Gatwick Airport Northern Runway Project

The Applicant's Response to the Examining Authority's
Written Questions – General and Cross-Topic

Application Document Ref: 10.16

PINS Reference Number: TR020005

Figure 26. Indicative Level 00 - South Terminal Immigration

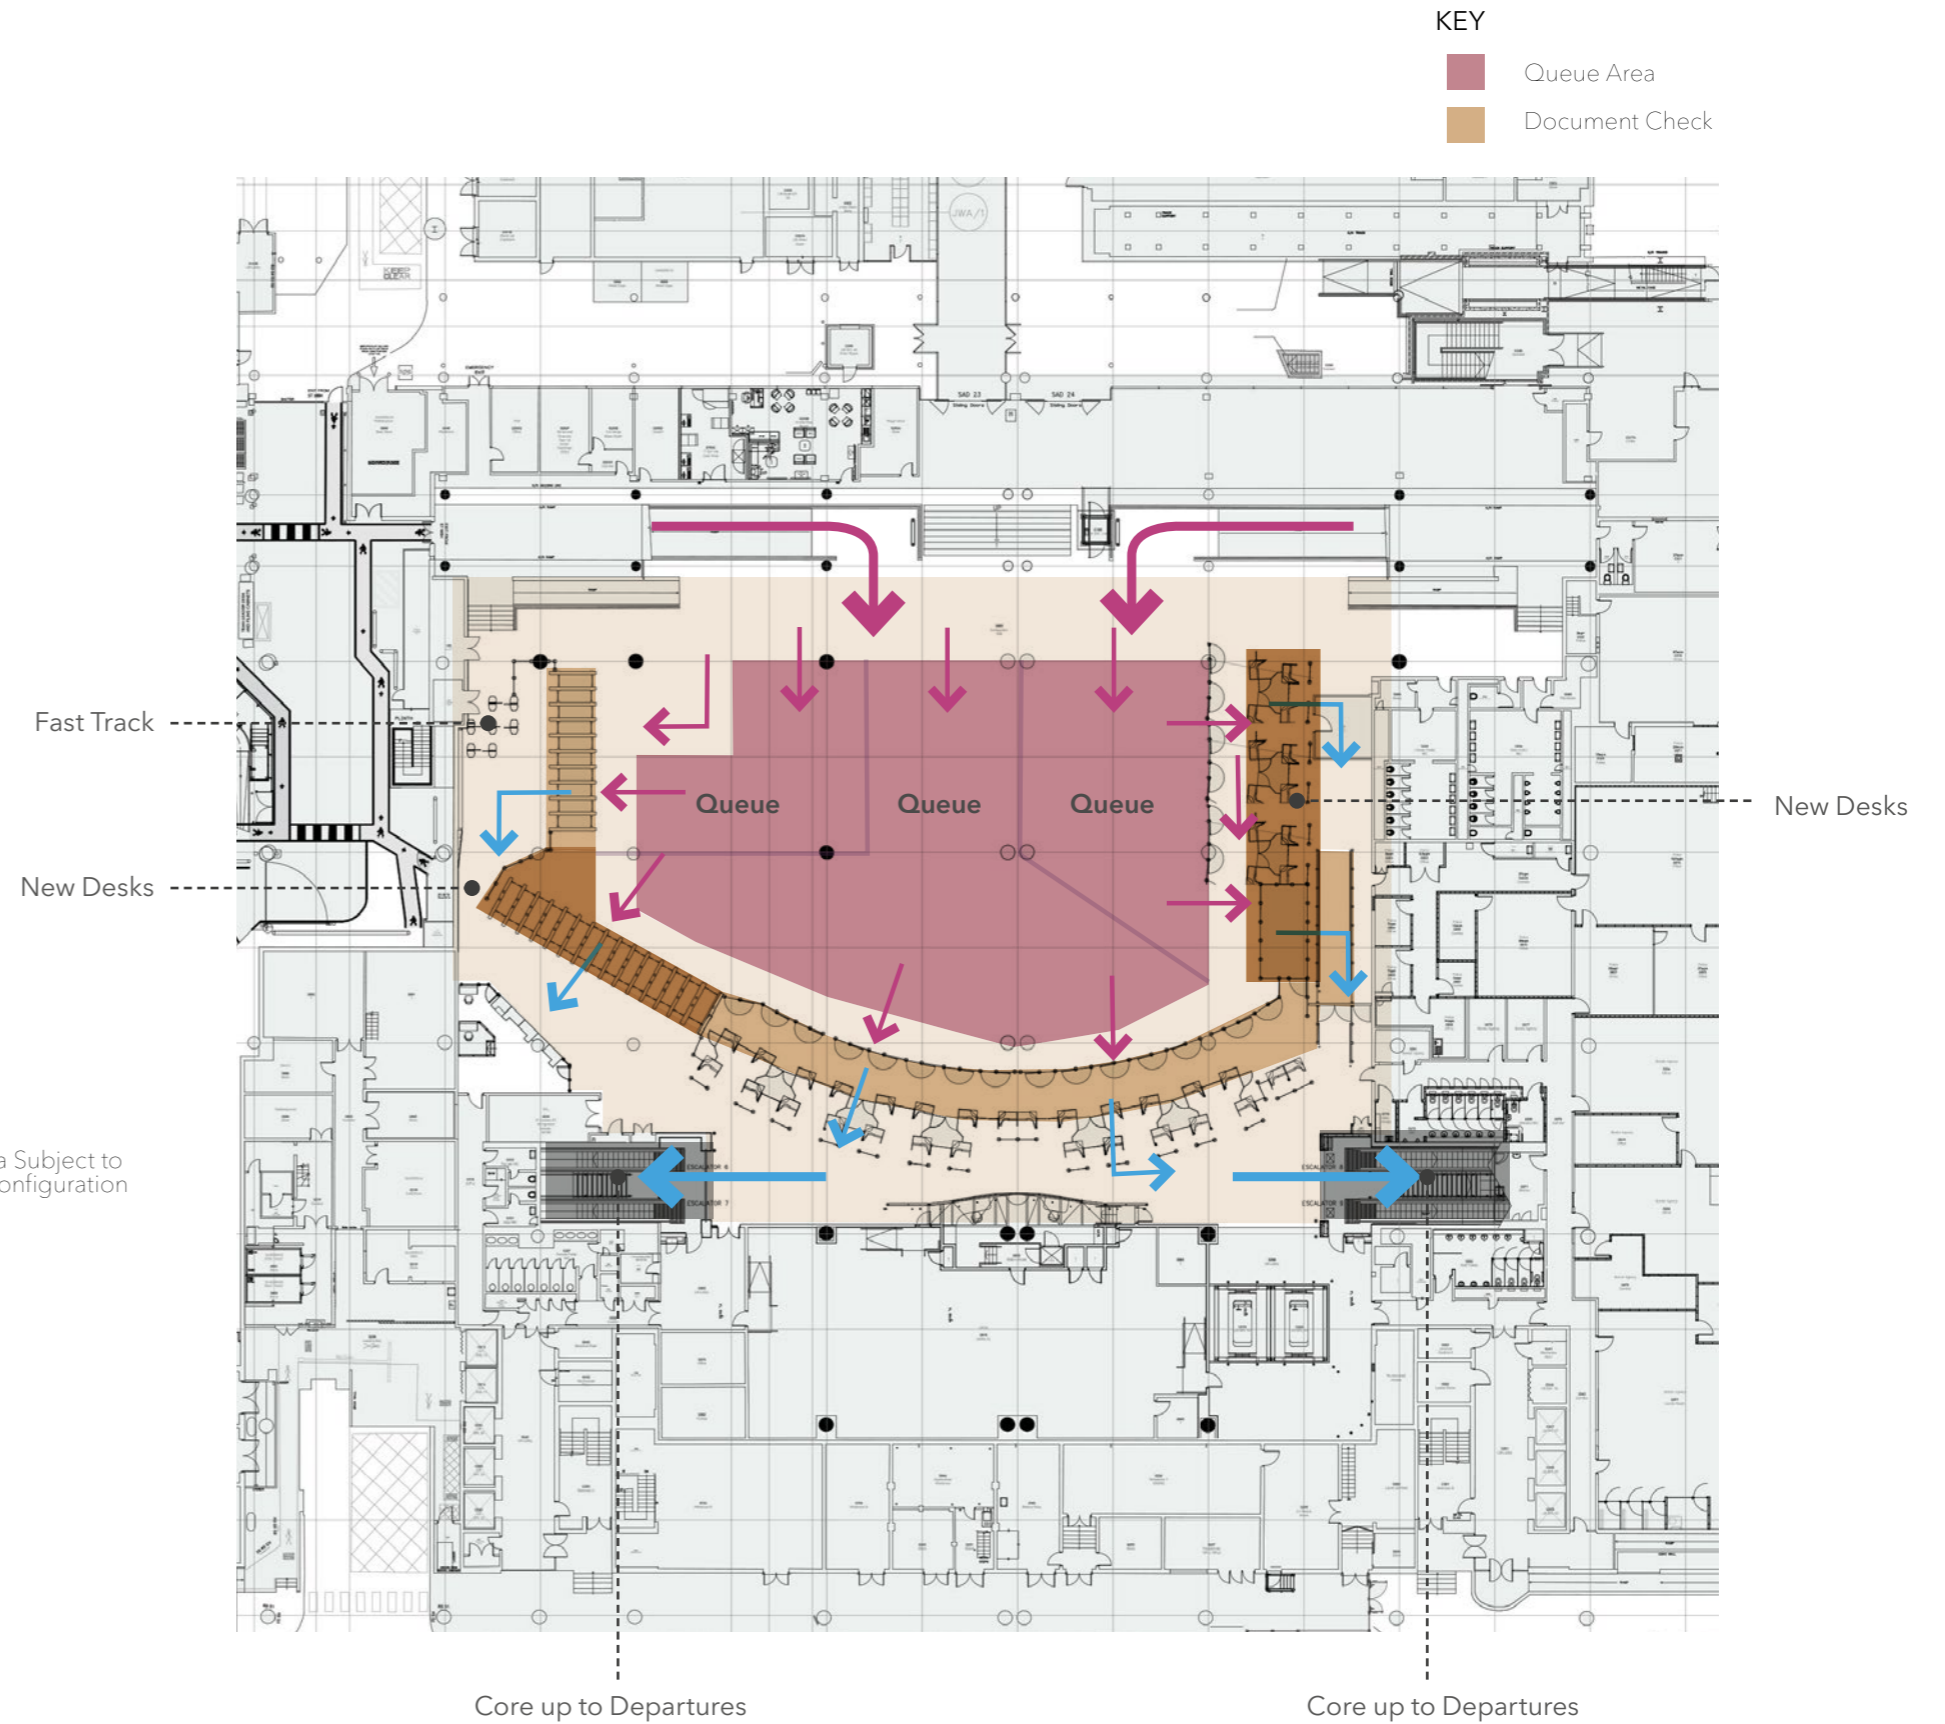
<p>Such plans should include proposed materials/ finishes:</p> <ul style="list-style-type: none">a) North Terminal IDL Extensions (north and south);b) North Terminal Baggage Hall;c) Pier 7;d) North Terminal forecourt;e) Car Park J Multi Storey;f) Car Park Y Multi Storey;g) Maintenance Hangar;h) Replacement CARE Facility (as amended);i) South Terminal IDL Expansion;j) Destinations Place Hotel;k) South Terminal Hotel (Car Rental Site);l) South Terminal Forecourt Hotel;m) Car Park H Multi Storey;
--	--	--

- Indicative massing drawings, floor plans and CGI images of the South Terminal IDL extension are included in **Figures 13 to 19** of the **Design and Access Statement Volume 4** [\[REP2-035\]](#);
